From: Neville, Julie [REDACTED] >
Sent: 06 October 2025 11:59
To: Planning
Subject: 3/2025/0507 Lower Reaps Farm Whinney Lane Mellor BB2 7EL
Attachments: 3 2025 0507 Overlay b.pdf

Reference 3/2025/0507
Location Lower Reaps Farm Whinney Lane Mellor BB2 7EL
Proposal Application for Planning Permission for conversion of barn to create new dwelling.
Construction of garage block. Demolition of existing farm block.

Lancashire County Council Public Rights of Way Team is not support of the application and provides the following.

project	project number
lower reaps farm - barn	24.50
name	
proposed - site and landscaping plan	
scale	status
1 to 200 @ A1	may 24 planning

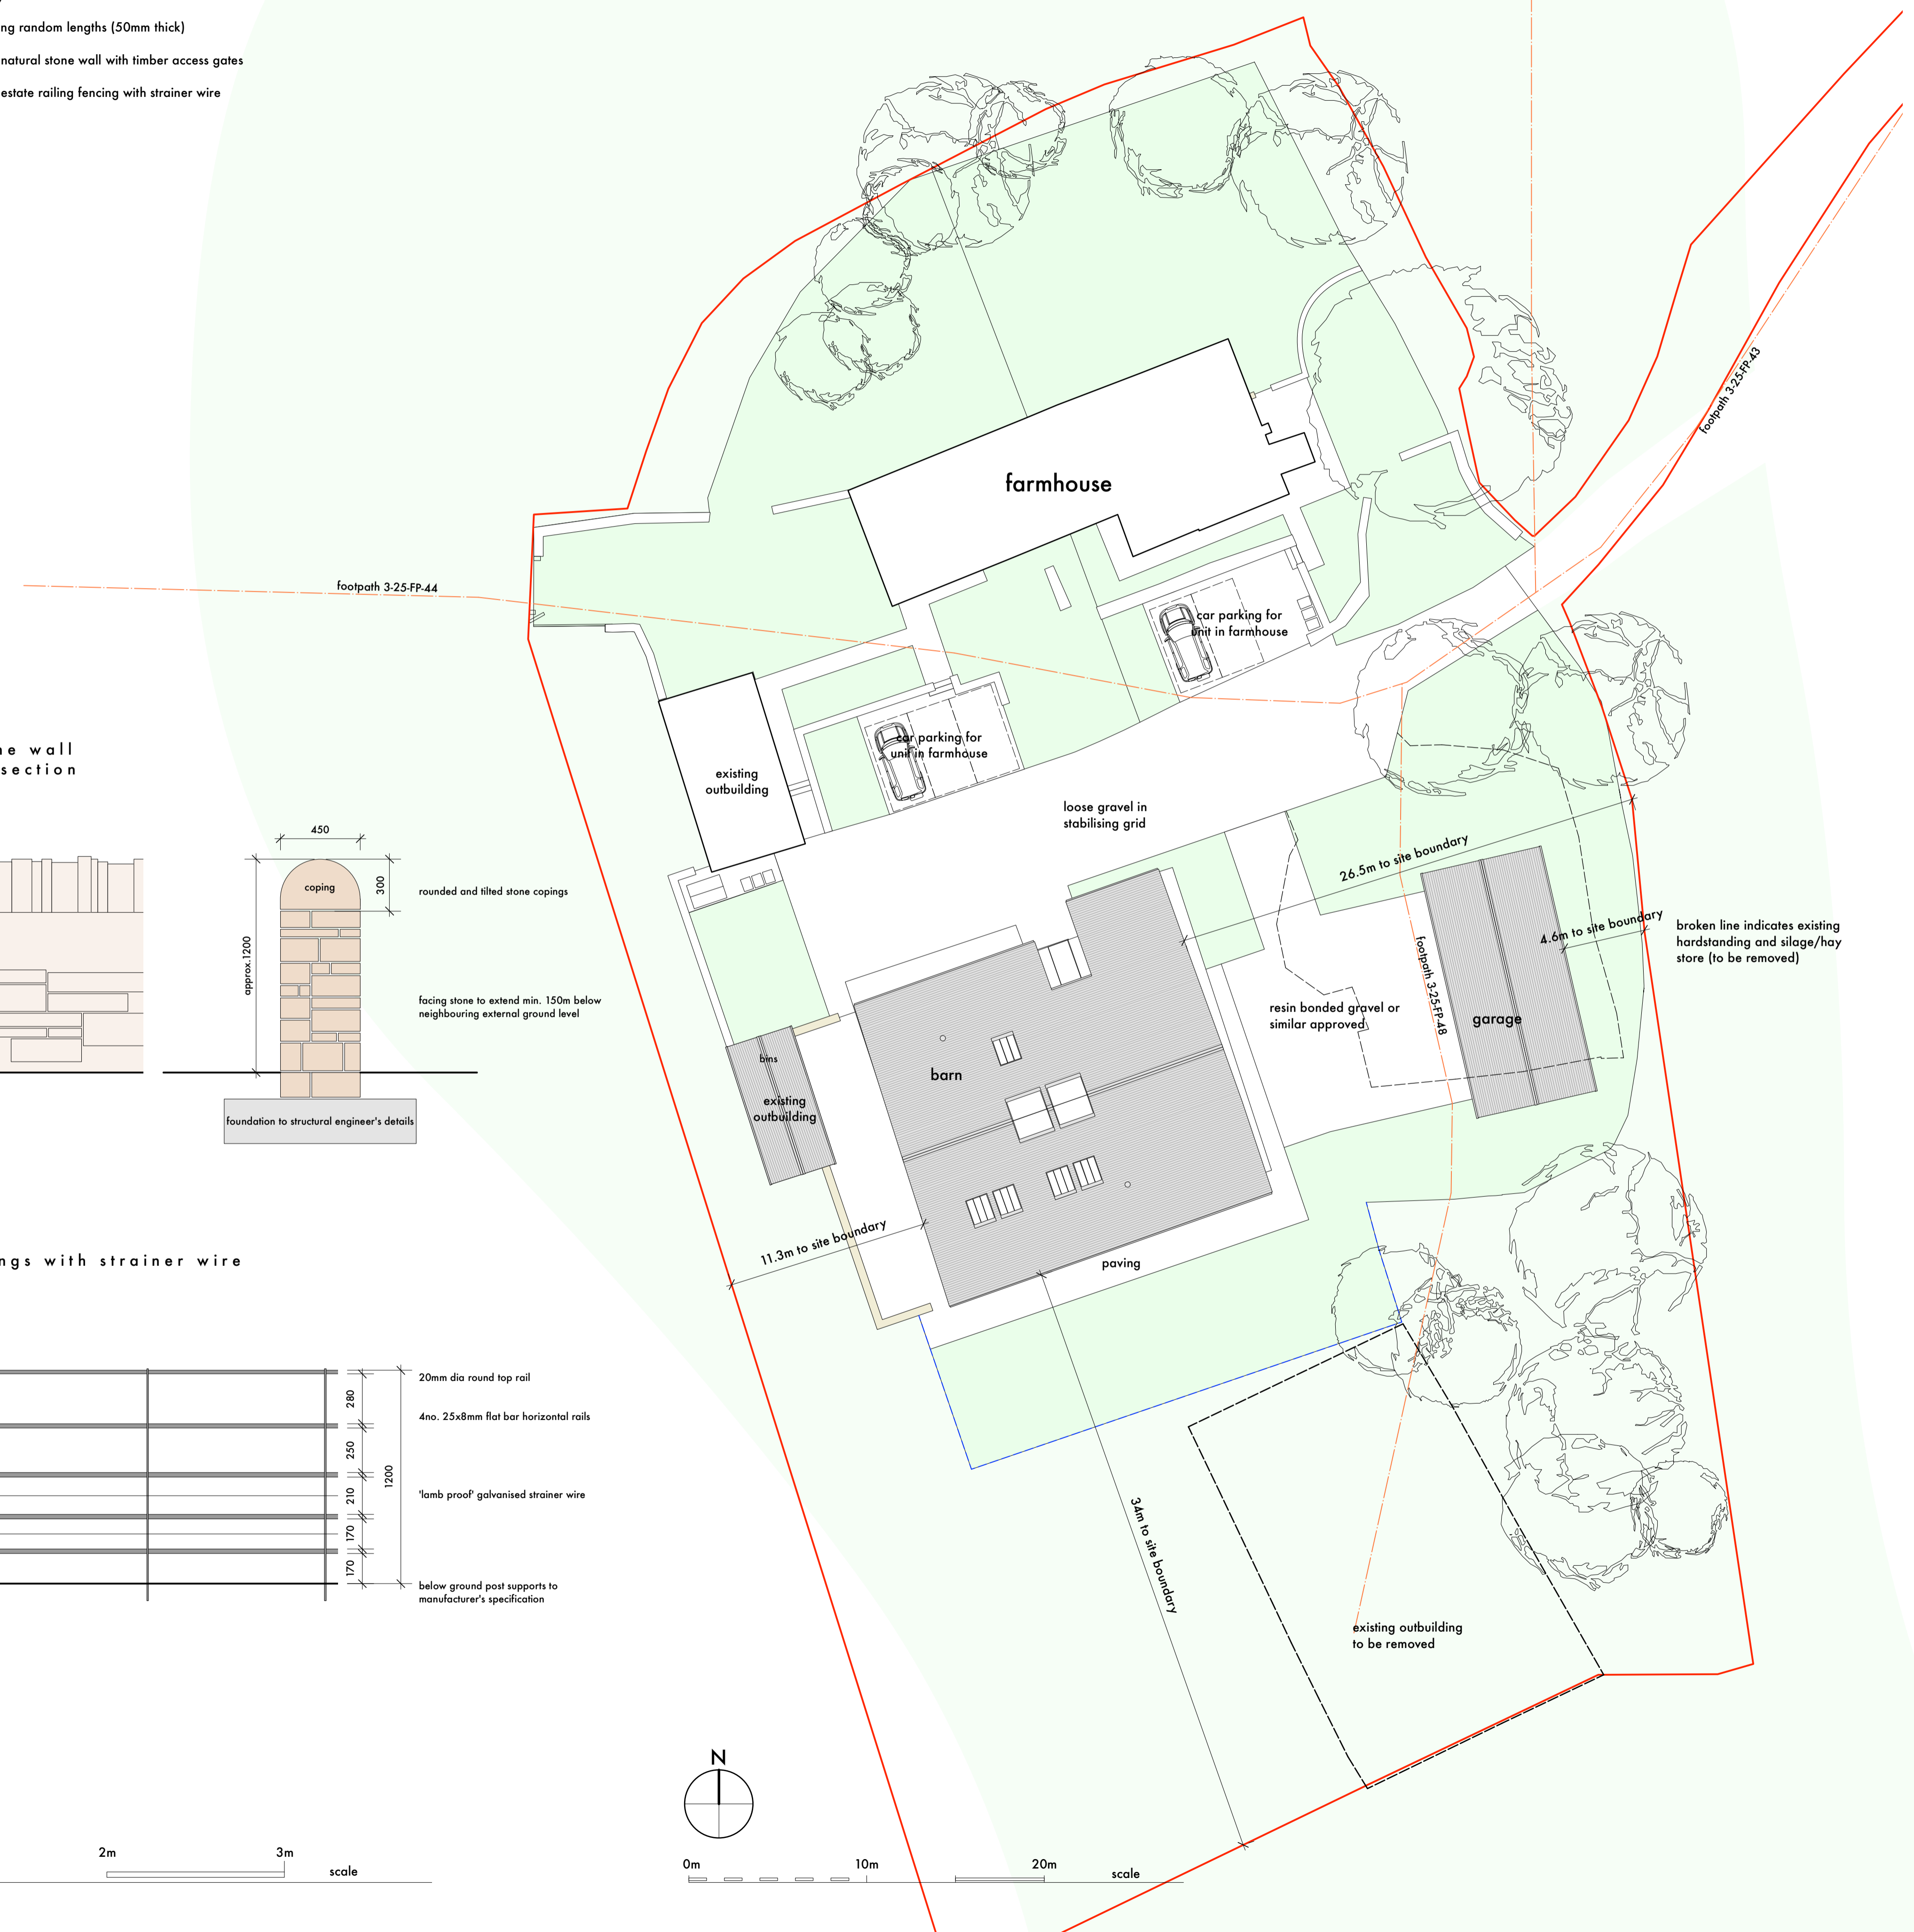
Footpath FP03250043 is recorded along the access to proposed development connecting to FP03250041, FP03250044 and FP03250048 which pass through the curtilage of Lower Reaps Farm, as shown by the indicative line on the attached overlay.

The National Planning Policy Framework 2024 places an obligation on developments to protect and enhance public rights of way and access, including taking opportunities to provide better facilities for users. It is the view of the Public Rights of way Team that the development does not meet this requirement as the proposed parking for the dwelling will obstruct the right of way. The granting of planning consent does not entitle the developer to obstruct the Public Right of Way and as such the plans require amendment to prevent this obstruction, which would be a criminal offence. The right of way should always remain accessible and not used to park or store materials, vehicles or machinery during or proceeding construction.

The Public Right of Way team is responsible for the surface of these footpaths being in a condition that is safe and fit for pedestrians, it does not maintain them to a standard that is appropriate for vehicle use. The team have no record of any public vehicular rights along the agricultural track recorded as footpath FP03250043, which will serve as access to the dwelling. The applicant should be certain that they have private vehicular rights along this public path before driving on it either during construction or for subsequent access. Without private vehicular rights or permission from the owner it is a criminal offence to drive a motor vehicle on the public path.
